Re: Kariong Sand and Soil Supplies Facility (SSD 8660)

Central Coast Public Health Unit (CCPHU) offers the following comments on the Response to Submissions (RTS) report and revised environmental impact assessment for the above project.

Figure 4. Tip & Spread Shed Design

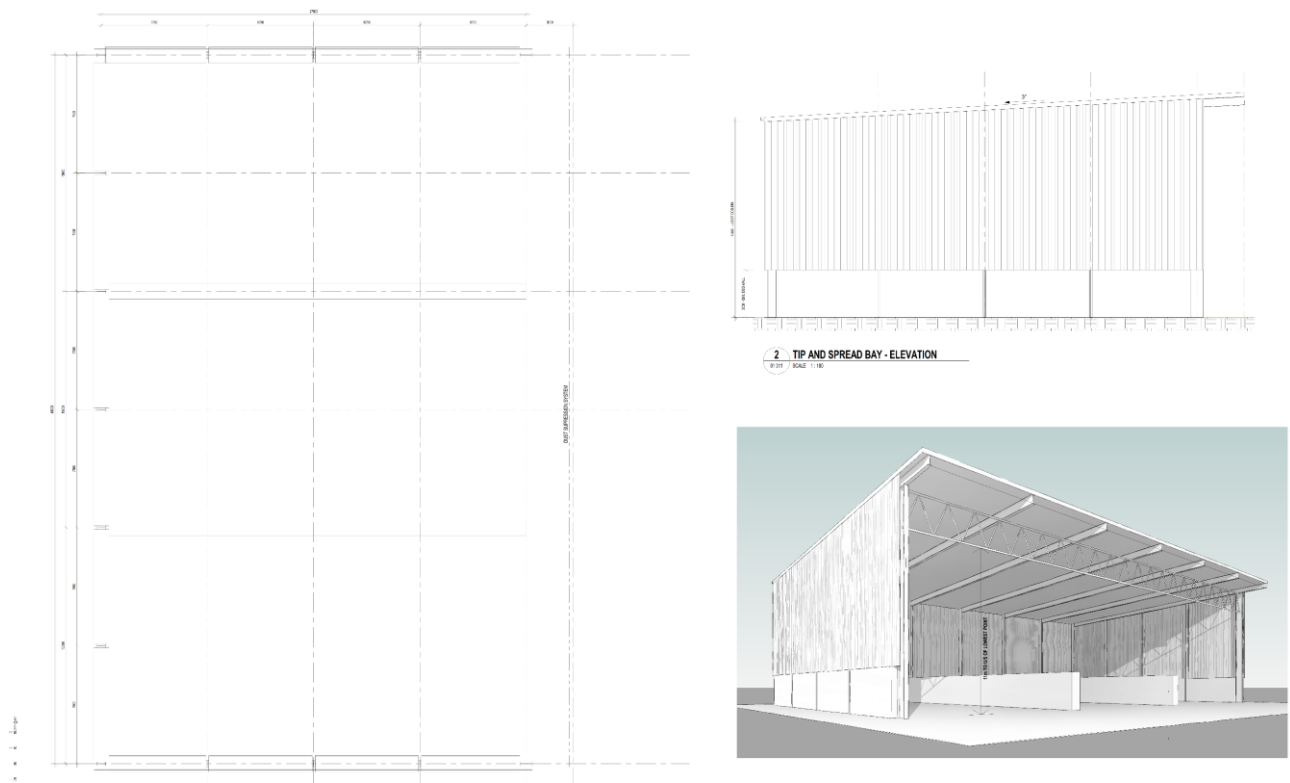
The use of mist sprays for dust suppression is relied on throughout the site. We seek confirmation that ceiling mounted spray misters will be effective in managing air quality impacts, especially in relation to the 11m high open face to the tip and spread building (AQIA Fig 3).
